Application for a non-material amendment following a grant of planning permission. Town and Country Planning Act 1990

REAR EXTENSION

ENT /386 /20 } BR /80/20 /HM

| Rev | By | Description | Date | Client                                                                                                                     | Status                                          |             |             |
|-----|----|-------------|------|----------------------------------------------------------------------------------------------------------------------------|-------------------------------------------------|-------------|-------------|
|     |    |             |      | Drawing Title                                                                                                              | Proposed Elevations & Section                   | Drawing No. | Revision    |

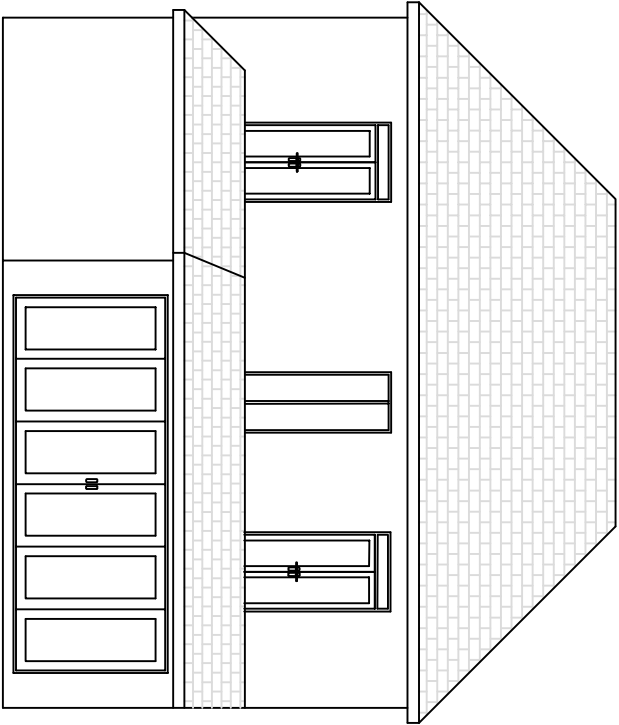
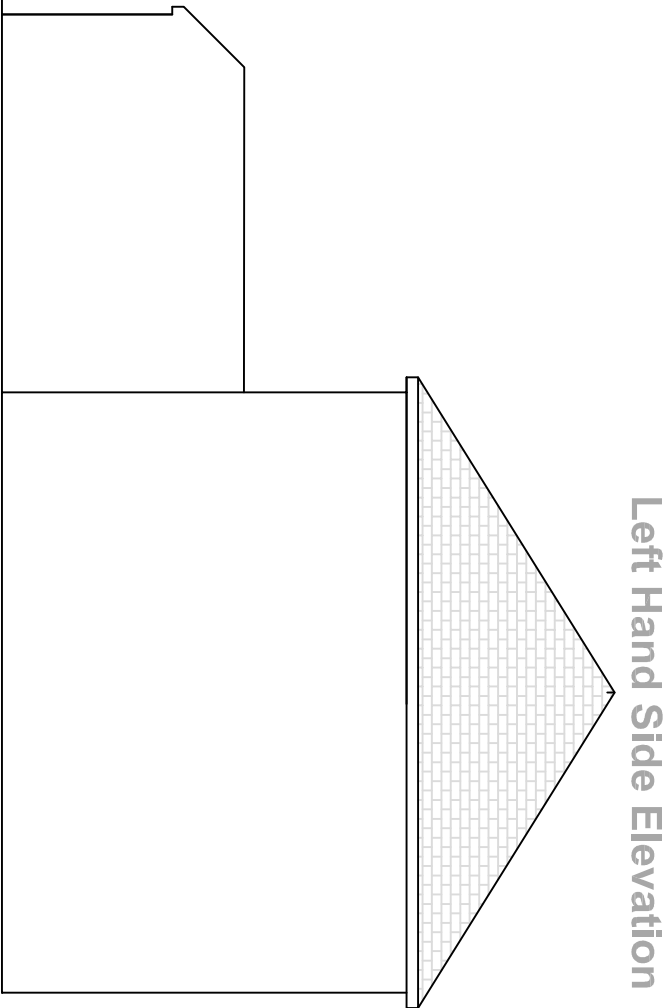
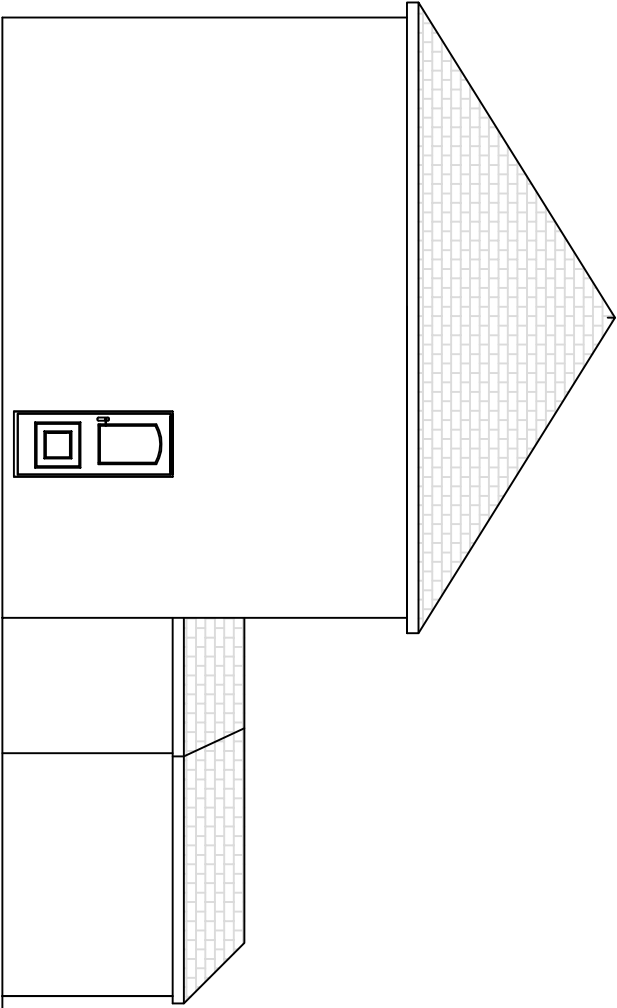
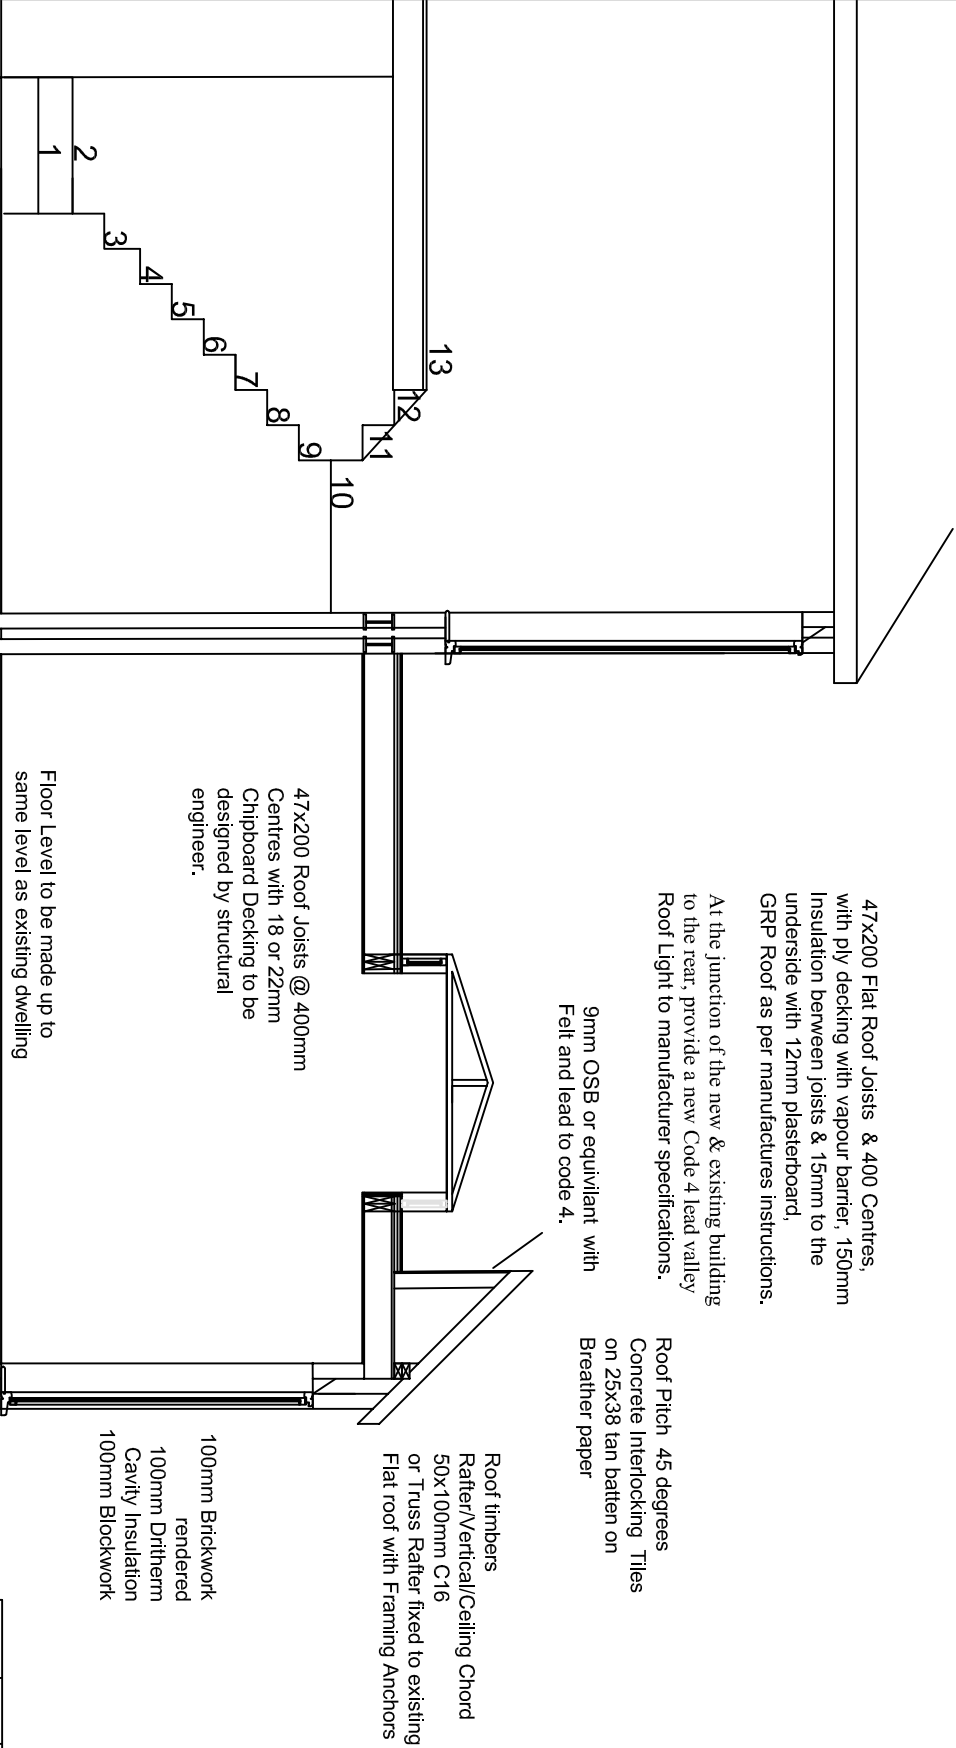
REAR WINDOW ADJUSTED

BOUNDARY INTRODUCED

Revised elevation & Section

Revised Section

DWG 3 Rev C , H Rev C
